Planning Application Reference No.: 3/2023/0180

Address of Development: Ashgreen House 4B Wiswell Lane Whalley

RE: PLANNING APPLICATION REF 3/2023/0180 - Erection of single storey dwelling with solar panels on the roof and air source heat system together with landscaped (patio) areas (amendments to planning permission 3/2021/0991)

DATUM 64.00
PROPOSED SECTION A-A
Scale 1:100

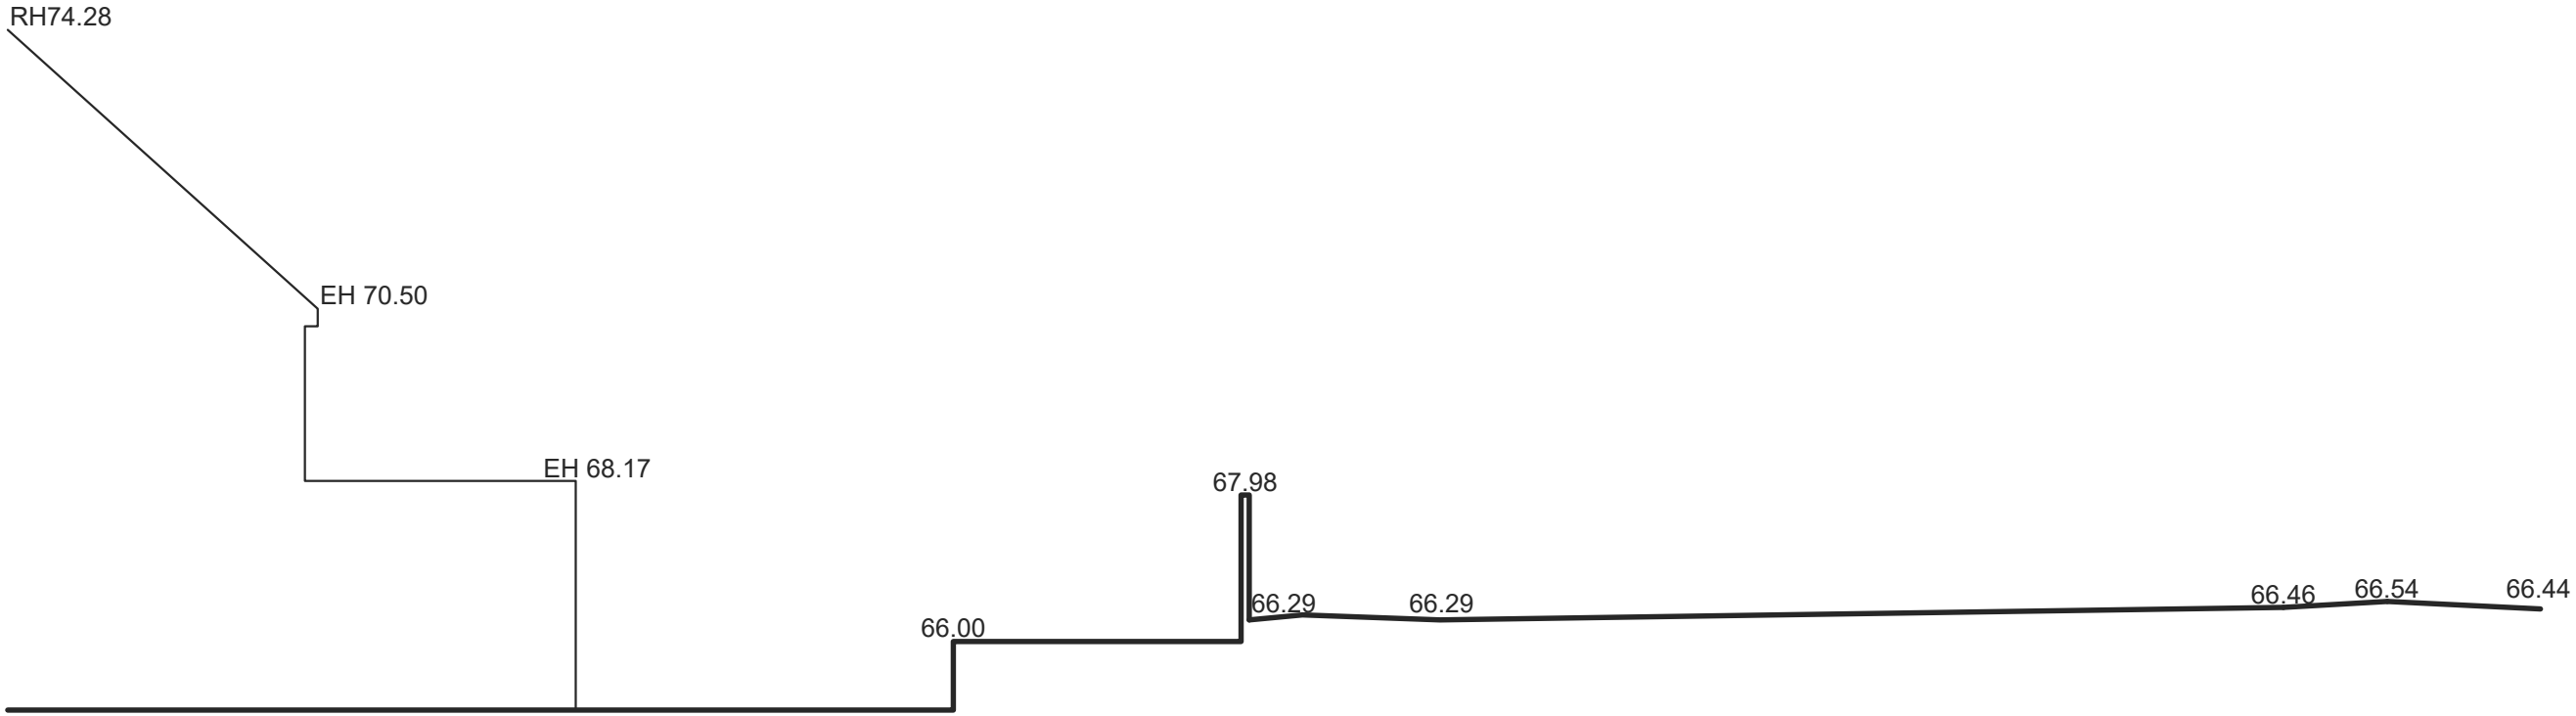
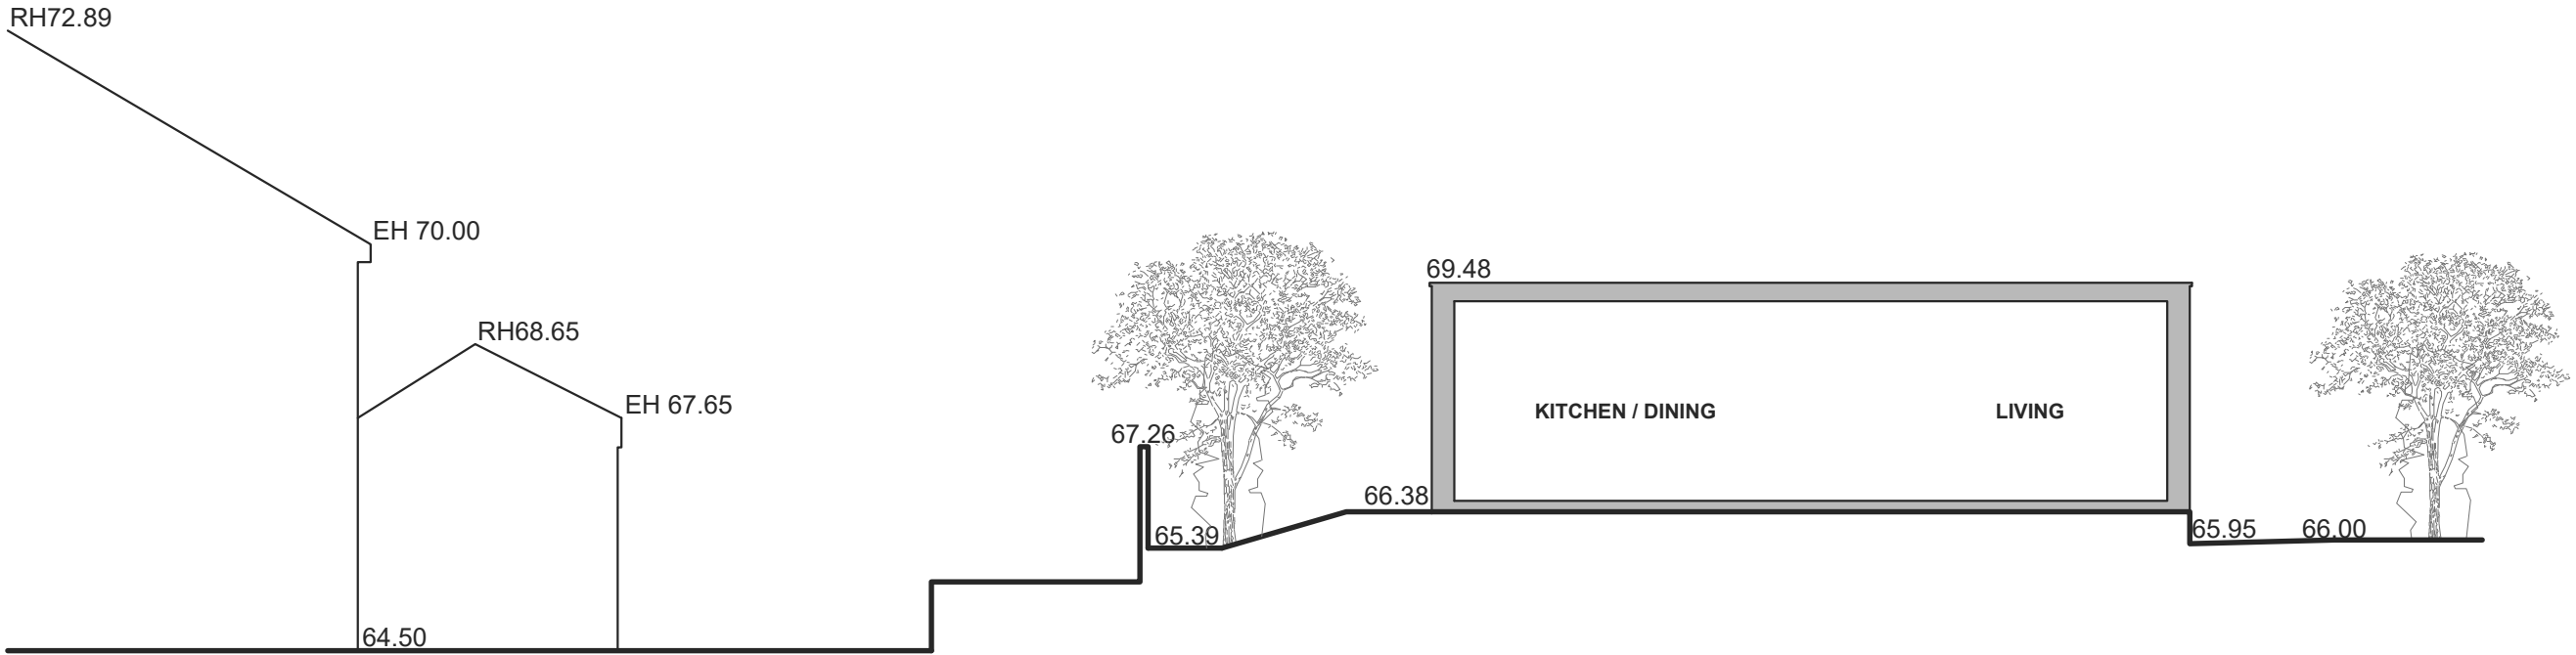
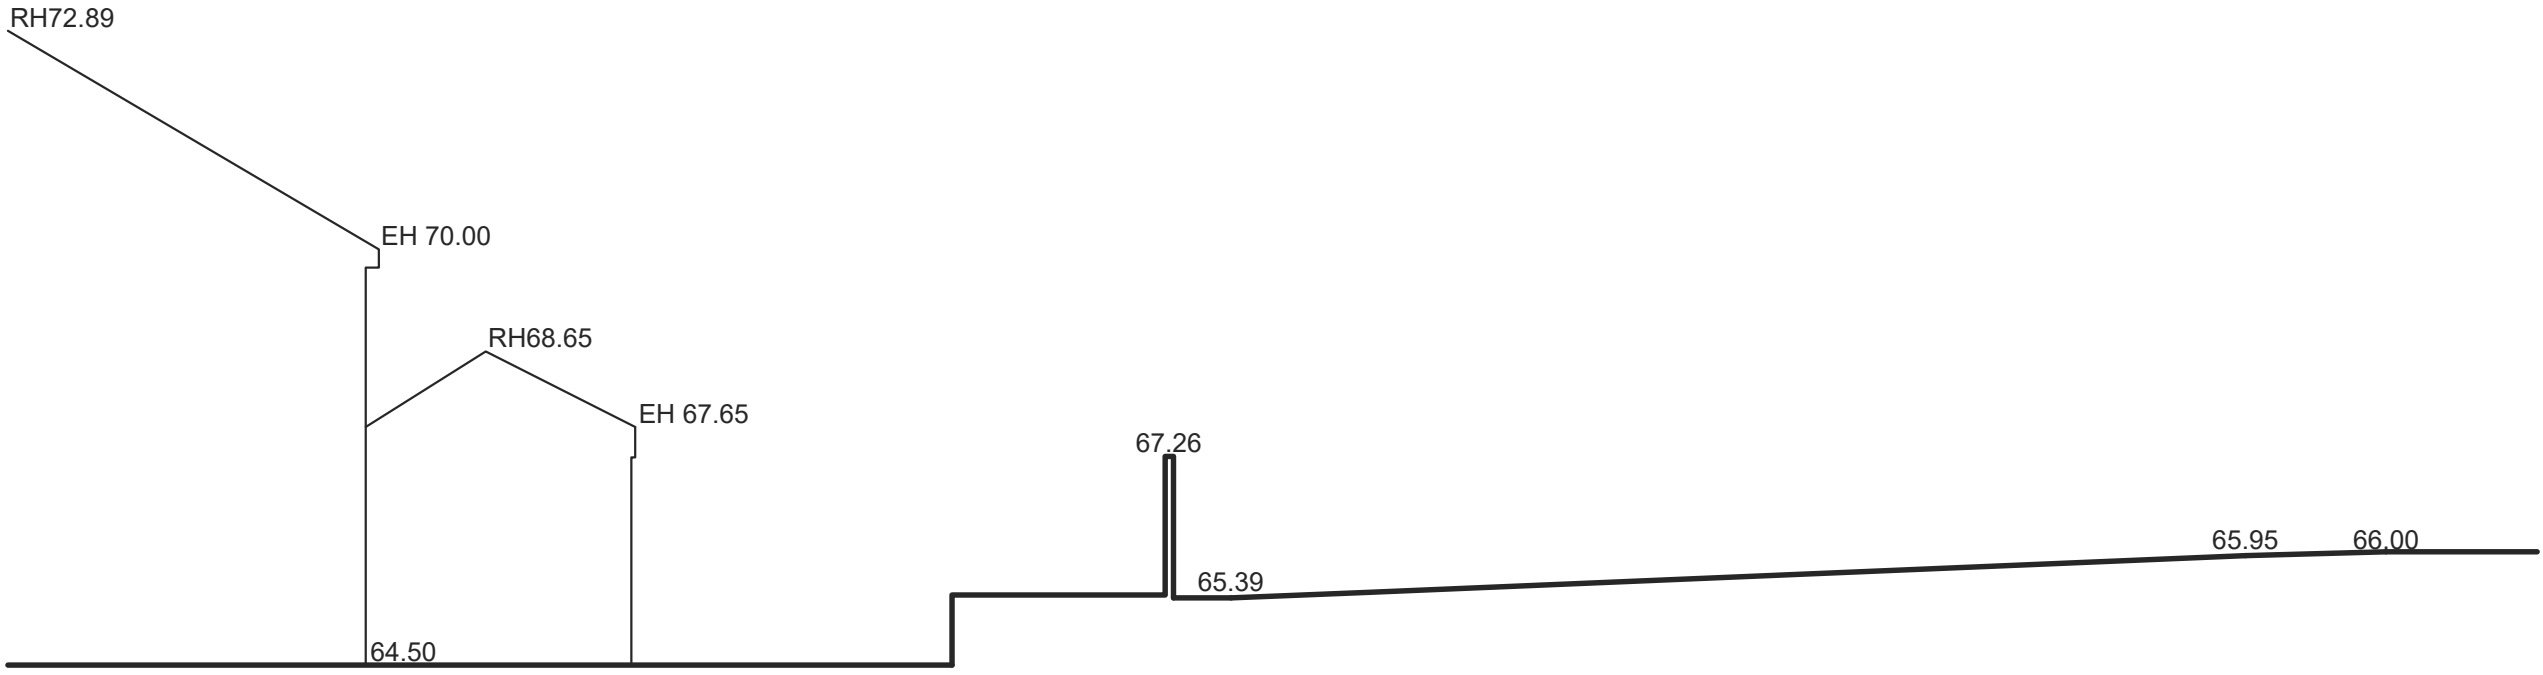
The new section drawings report the ground level to be at 66 meters above sea level (assuming the unit is meters), whereas the original west facing cross section demonstrated it to be at the same ground level as the house [REDACTED] therefore the ground level should be at about 63m. I accepted these original plans because as the build moved east (up the hill) to be compliant with the drawings the owner should have dug down to maintain that level. Therefore minimising any visual impact or overlooking [REDACTED]

The recent changes in the planning application have increased the ground level to 66 meters at the west elevation, effectively altering the original approved ground level by circa 3 meters. This adjustment, in addition to the 0.4-meter height increase, significantly impacts [REDACTED] by making the building more visually prominent and obstructive than initially proposed. Reducing light, creating an eyesore, and more importantly they have very clear [REDACTED]

This has resulted in the building being far too high at one end (approx. 2.475m [REDACTED]) The ground floor level at one end (the west/kitchen end) almost is the height [REDACTED] At the west side the overall height of the 'bungalow' is the [REDACTED] This is demonstrated on drawing '230180 site sections' as being near [REDACTED] (not shown on the revised sections). As it stands this is not the one storey height bungalow, we were expecting from the original plans it is roughly 5.1m [REDACTED]

10. A section plan has been submitted alongside application 3/2023/0180 which is attached (appendix 8).
11. It must be appreciated that the site falls approximately 1.86m from the East Elevation to the West Elevation. This can be picked up from the TOPO plan attached to the application (Appendix 6). It must also be noted that considerable earth works were undertaken by [REDACTED]. It can be seen via the lie of the current land up against the boundary fence from the neighbouring properties of Deer Park Crescent which in fact arrived in c2014-2015 and thus were installed to a height of approx. 1.8m above the. Then, current ground level. Therefore, any earth that is piled up against this boundary fence line is in fact a recent addition.

12. Given that the land falls away from East to West (referring to the site plan) it would have been helpful to see a section on the West Elevation which would confirm the true impact of the proposed dwelling. In absence of this, it is quite easy to calculate given the applicants TOPO has picked up the existing fence line level on or around the Western elevation and this reads as 66.85. Taking the proposed finish height of the dwelling to be 69.48 this gives an impact of some 2.63m. For reference a standard boundary fence is approximately 1.80m in height and a standard residential doorway 2.10m. This is completely unacceptable and wildly different (double in fact!) from the initial approved application which stated the finished height of the building would sit some 1.30m above the fence line.

13. Furthermore, it can be seen from section B-B that the Finished Floor Level of the building is some 1m higher than the external ground level. Comparing that with the neighbouring Deer Park Crescent property, who's FFL is assumed to be 64.50m that is a difference of 1.88m (66.38 less 64.50). [REDACTED]
